**Addendum No. 1**

RE: Contract ID C202873

**Carteret County (BK-5128)**

Replace Fender System Bridge #6 on NC-58 Over Atlantic Intracoastal Waterway  
Between NC-24 and Emerald Isle

PROJECT NO. BK-5128
CARTERET COUNTY
SHEET 1 OF 6

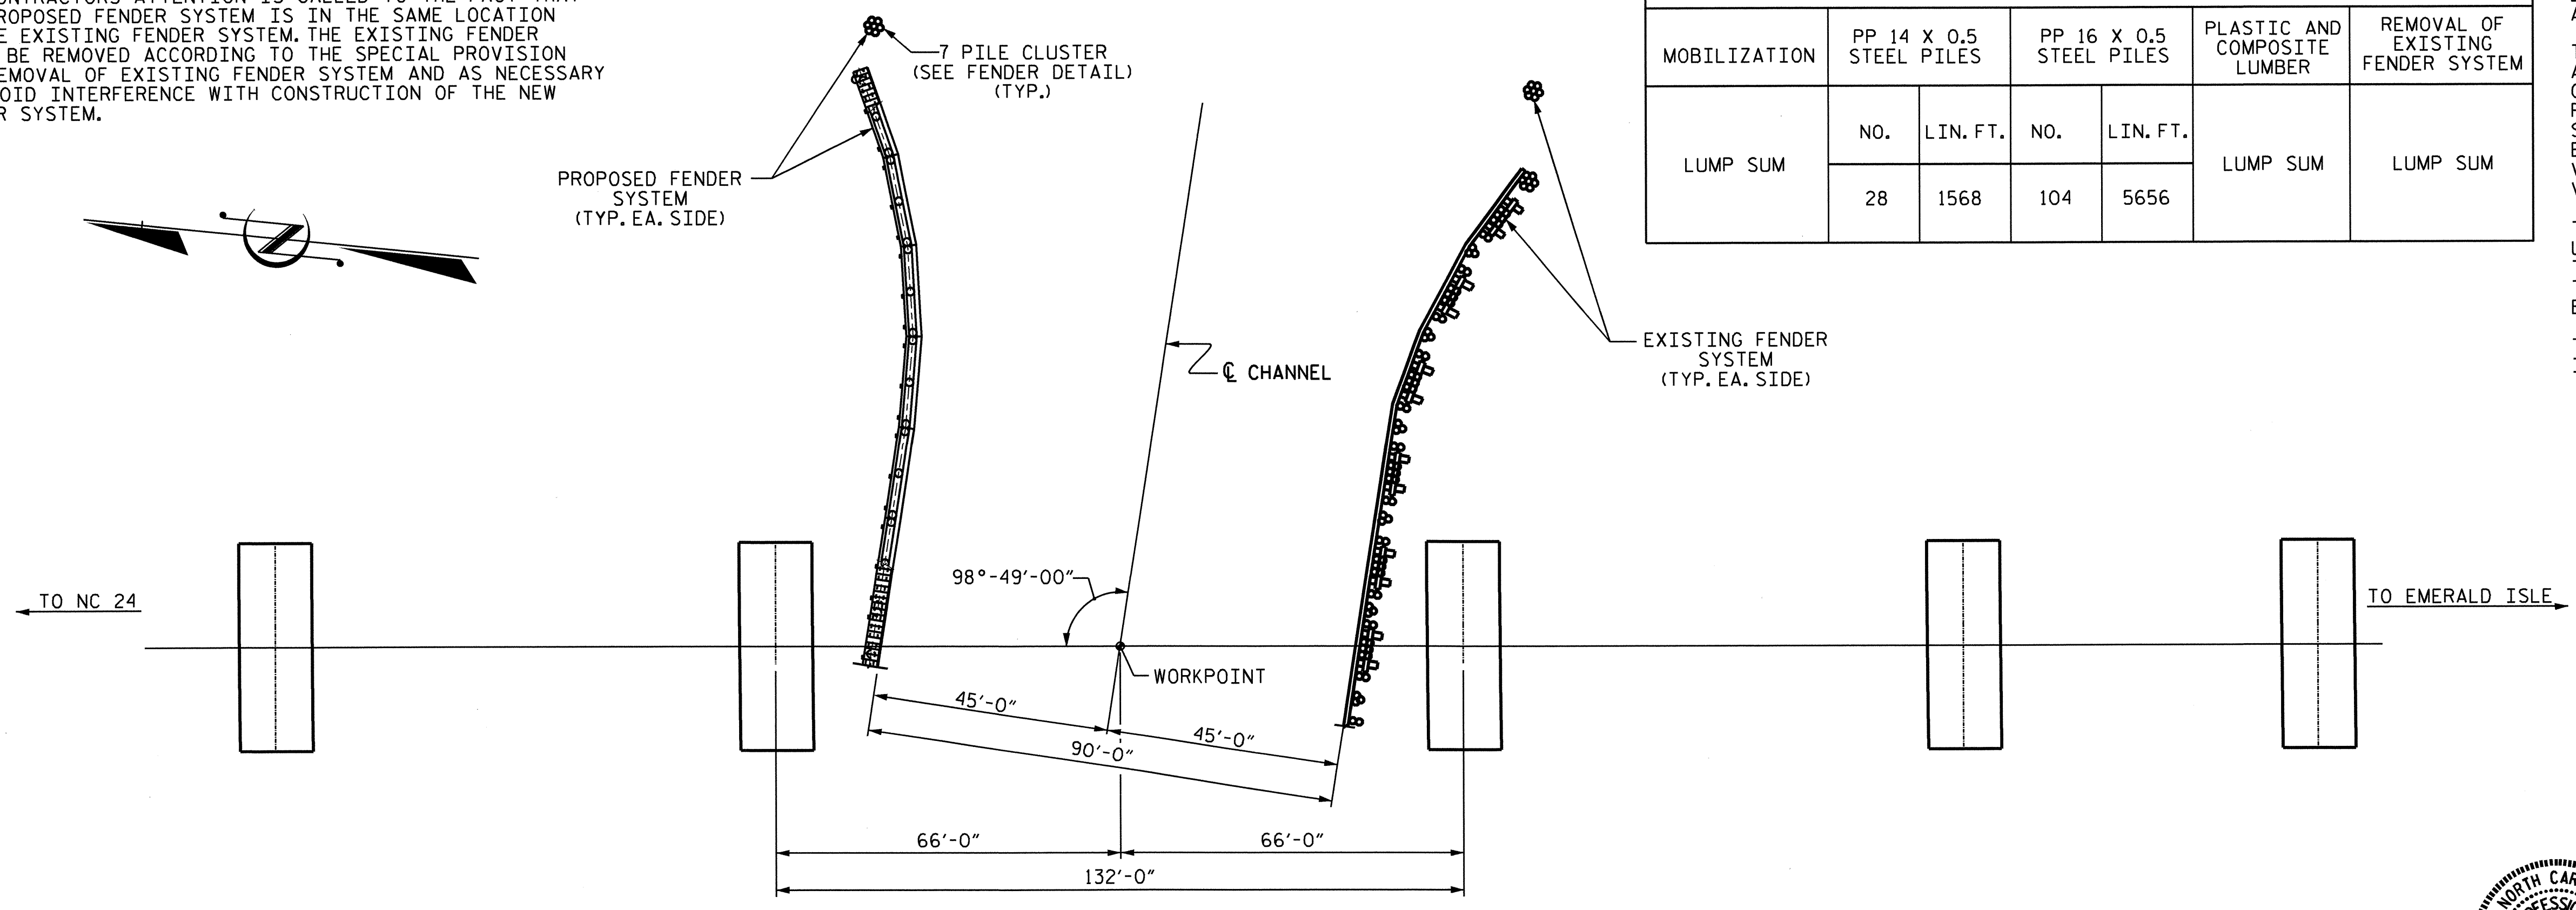
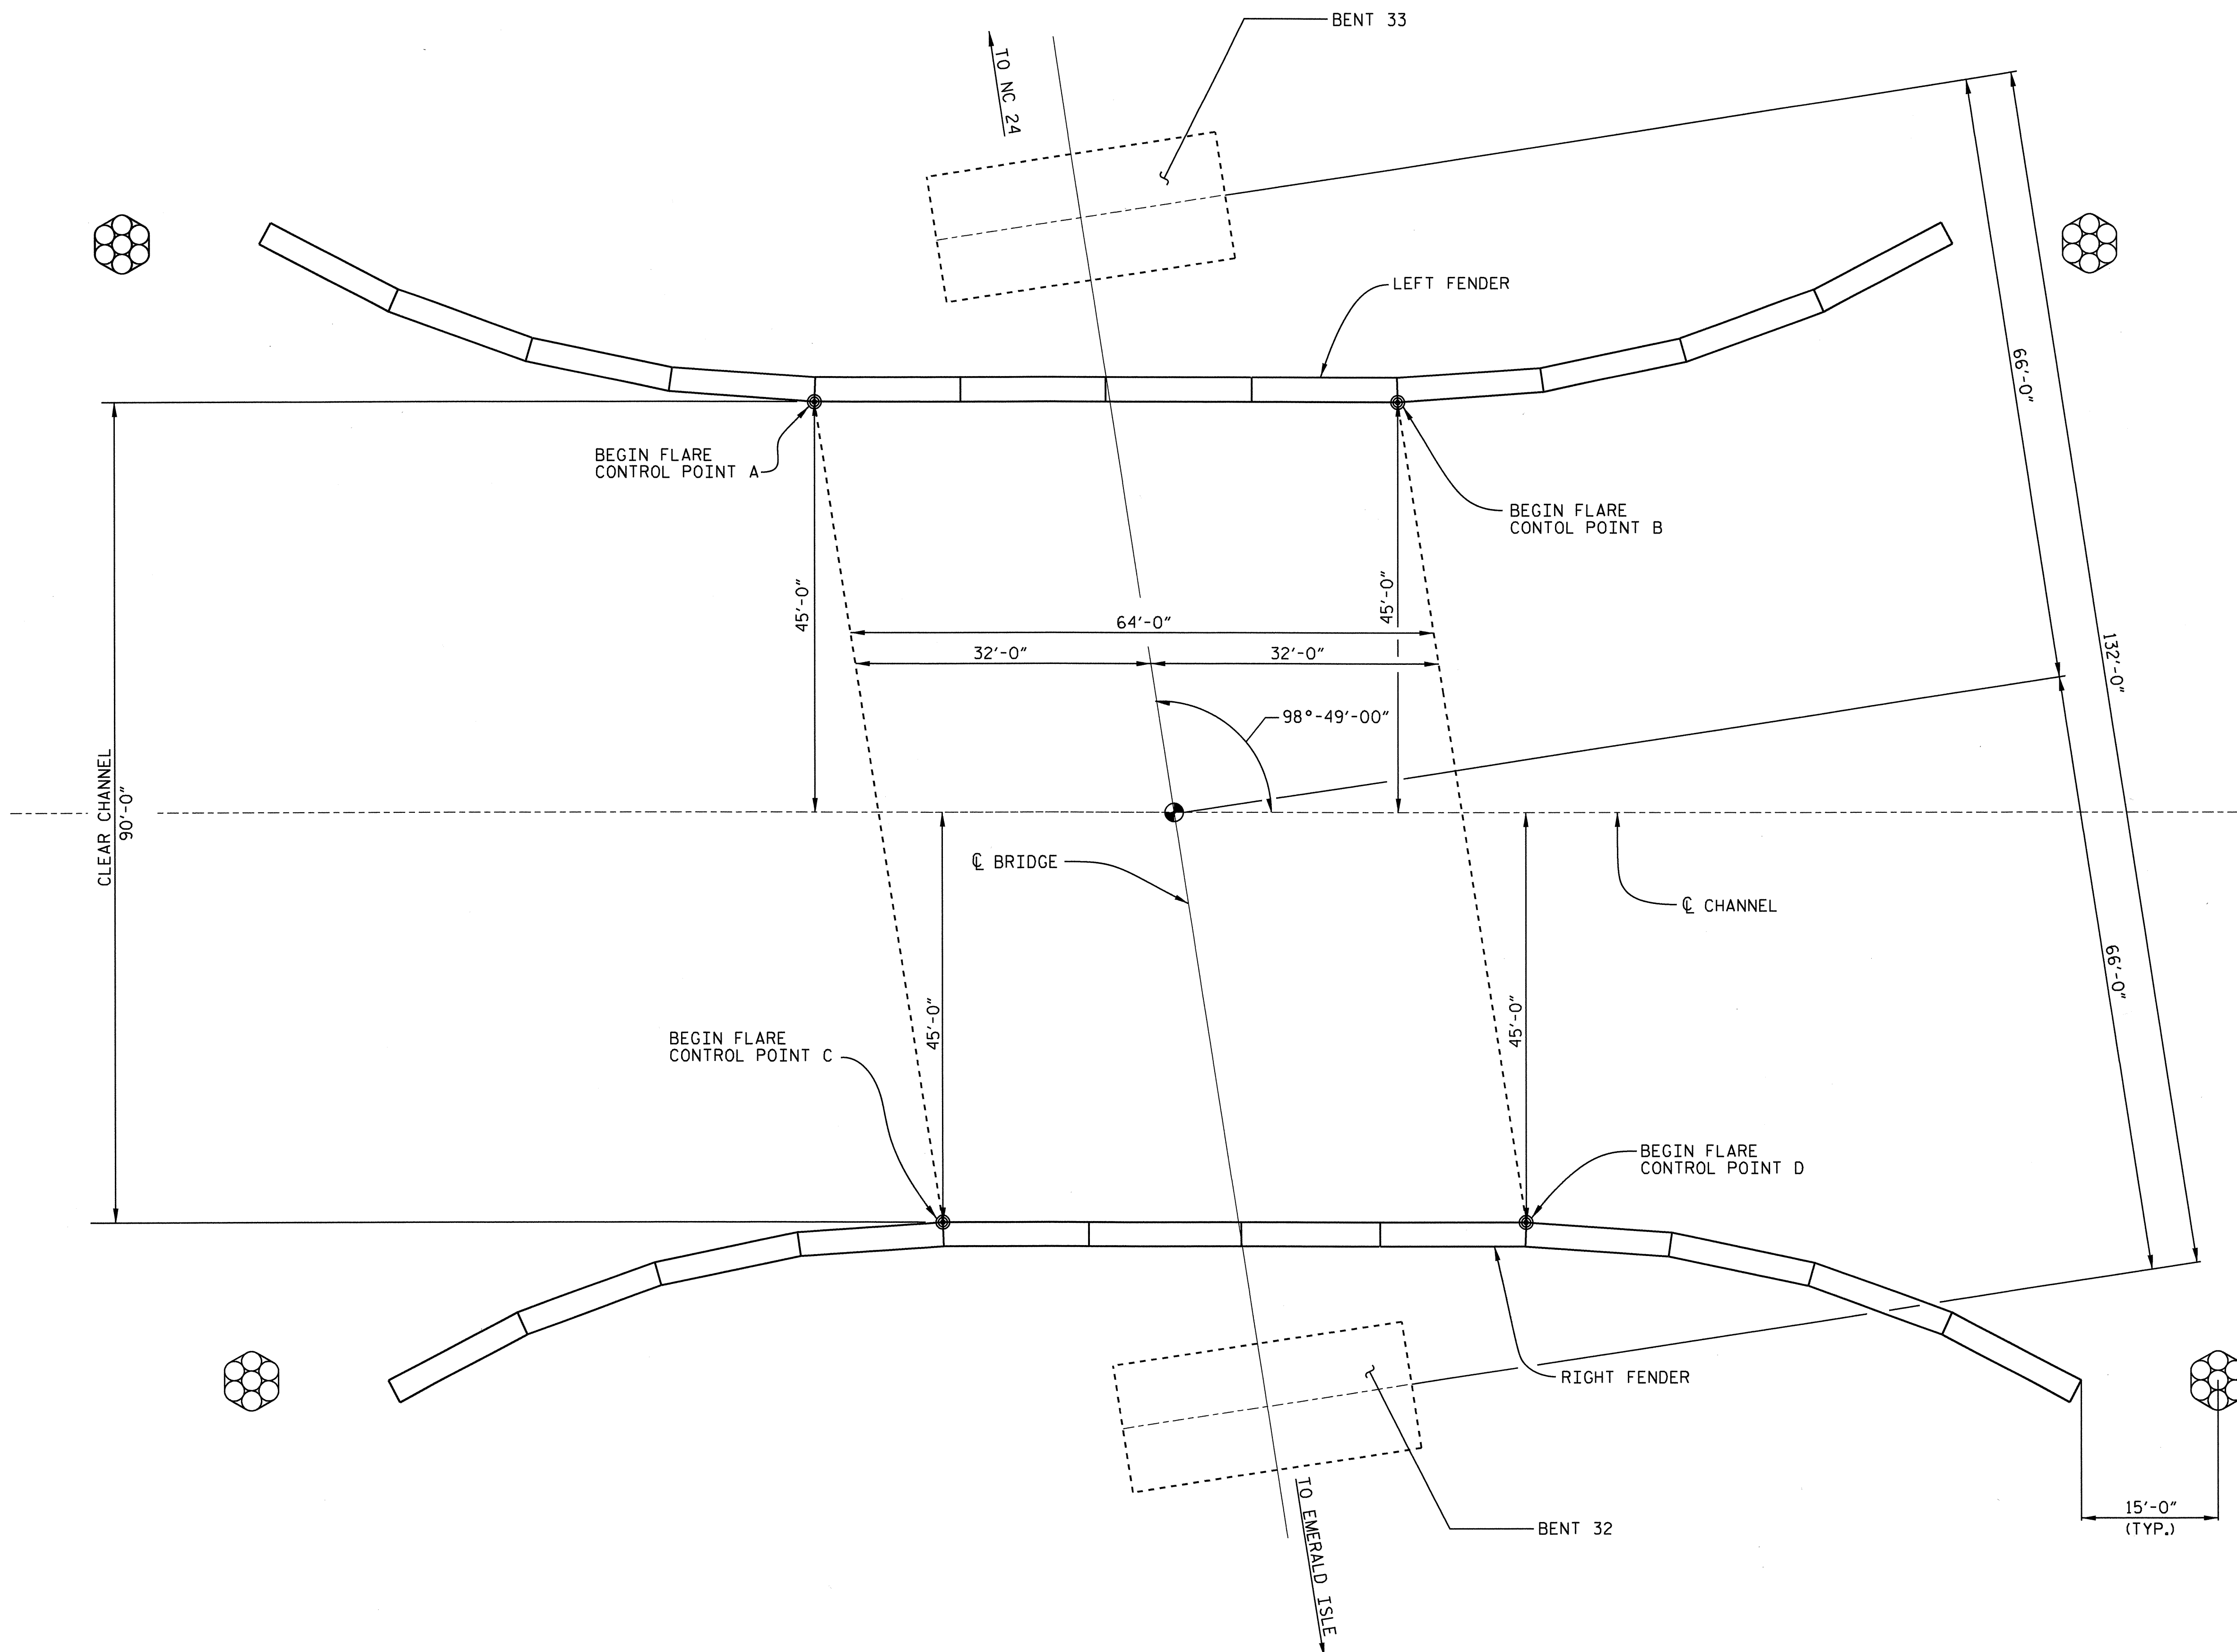
On Sheet S-1a note concerning cutting holes in piles has been added. Please void Sheet No. S-1 in your plans and staple the revised Sheet No. S-1 thereto.
